**NORTH FALLS OFFSHORE WIND FARM DEVELOPMENT CONSENT ORDER**

**PINS REFERENCE EN010119**

**DEADLINE 6: PORT OF LONDON  
AUTHORITY'S COMMENTS ON SUBMISSIONS  
RECEIVED AT DEADLINE 5**

Deep Water Route Cable Installation Areas (Future Dredging Depths) Plan

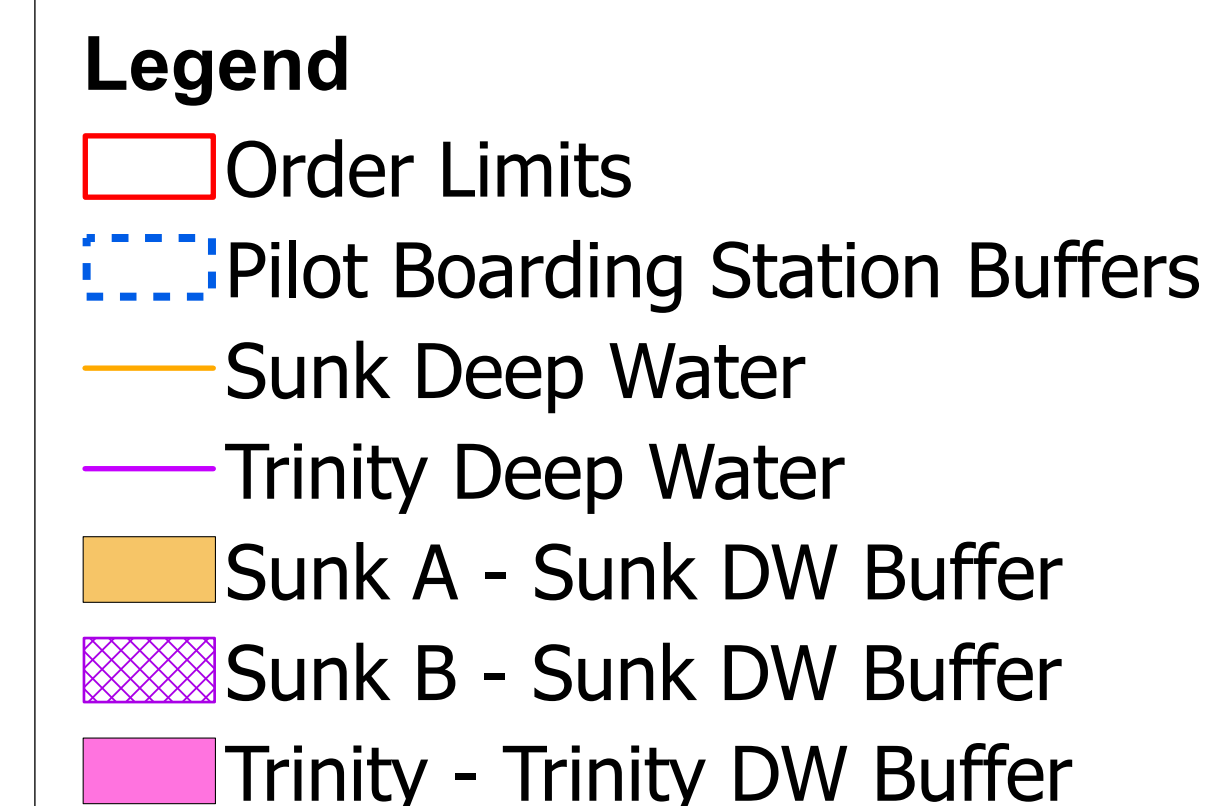
2.2 Figure 3-1 which showed the disposal zone constraints, including the ‘Sunk DW Buffer’, the ‘Trinity DW Buffer’ and the ‘Pilot Boarding Station Buffers’ has been removed from the document and reference is now made to the Deep Water Route Cable Installation Areas (Future Dredging Depths) Plan [REP4-043]. The commitment in paragraph 21 of the oSDMP now states that *“all disposal material that is created from construction activities will not be disposed of within the areas proposed for deeper burial of the export cable (“Sunk A – Sunk DW Buffers”, “Sunk B – Sunk DW Buffers” and “Trinity – Trinity DW buffers”) shown in in Deep Water Route Cable Installation Areas (Future Dredging Depths) Plan [REP4-043].”* The PLA has no objection to this revised wording and has highlighted a minor typo that requires correction in underline.

2.3 A similar approach, which refers to Plan REP4-043 is now taken in relation to the Pilot Boarding Station Buffers and paragraph 25 has been updated, removing the words “where possible” and making the commitment clear in relation to the pilot boarding area. This is welcomed.

2.4 The only outstanding matter relates to ensuring that any disposal material should also not be placed in areas that could migrate into either the deep water routes or the pilot boarding area. The approach to this should be clear in the oSDMP.

- a. Regarding the Updated Requirement 2(3), the Requirement should reference the authorised development rather than just "*Work No. 3 and any associated development*" and include a sub-paragraph (4) as included in the PLA's response to ExAQ2 to read:

*(4) The undertaker must not carry out wet storage or relocate any boulders or archaeological finds to or within the three areas referred to in paragraph (3).*

(3) Any part of Work No. 3 and any associated development located within the following areas shown on the Deep Water Route Cable Installation Area (Future Dredging Depths) Plan, must be **designed**, installed, **operated** and maintained at a level which would not preclude **or impede** dredging:

(a) of the area shown shaded in orange and labelled Sunk A – Sunk DW Buffer, to a level of 22 metres below Chart Datum;

(b) of the area shown shaded in pink and labelled Trinity – Trinity DW Buffer, to a level of 22 metres below Chart Datum; and

(c) to the area shown cross hatched purple and labelled Sunk B – Sunk DW Buffer, to a level of 19 metres below Chart Datum: ("**the Updated Requirement**")
